City File Number: DEPN-25-0173 / County File: OAR 265

Review 4

OAR2610: Rock Creek Mesa Development Plan

EPC DPW DS- Engineering

ROCK CREEK MESA FILING NO. 1
FINAL PLAT
A PORTION OF THE SOUTH HALF OF SECTION 30, TOWNSHIP 15 SOUTH, RANGE 66 WEST
CITY OF COLORADO SPRINGS, EL PASO COUNTY, COLORADO

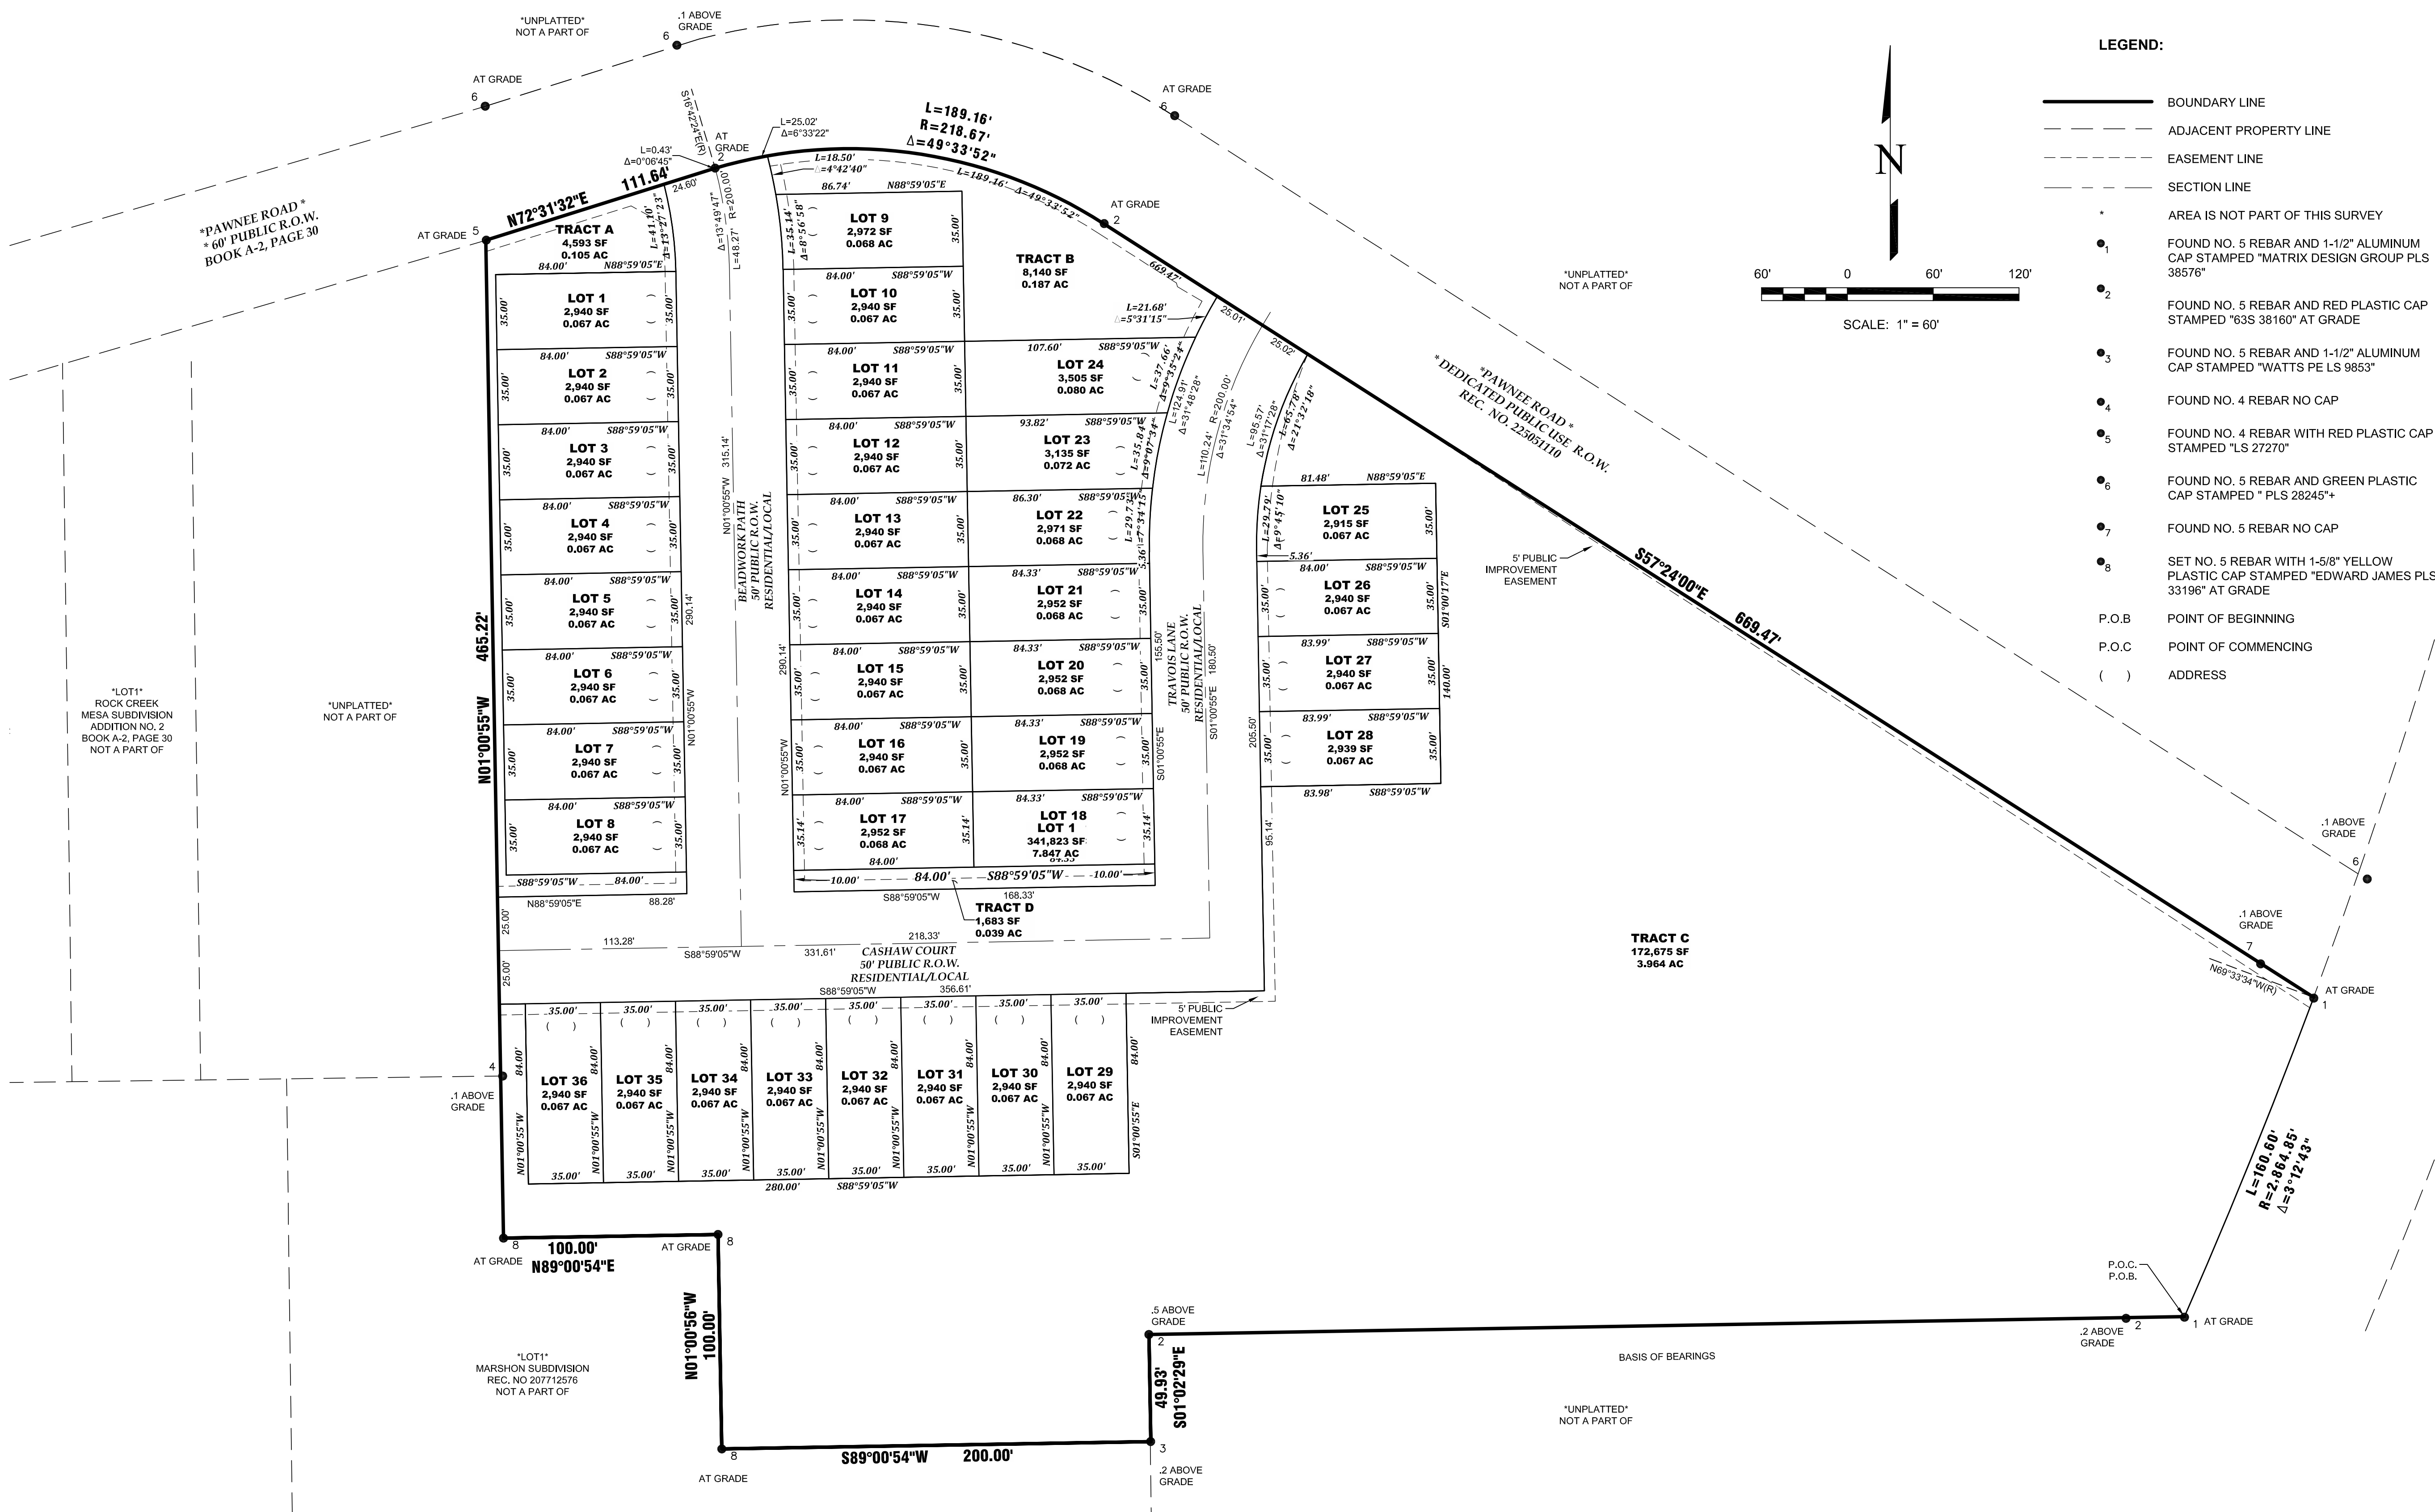
V3_(Missing) add a plat note on the plans indicating that the Trail construction in Tract A and up to the

property limit are the responsibility of the Developer for Rock Creek Mesa (Rock Creek Mesa cannot land lock the County parcel to the NE and the parcel/s to the north; in addition, add a note on the plat that allows access on Rock Creek Mesa and up to the offsite parcels to the Northeast and to the North.
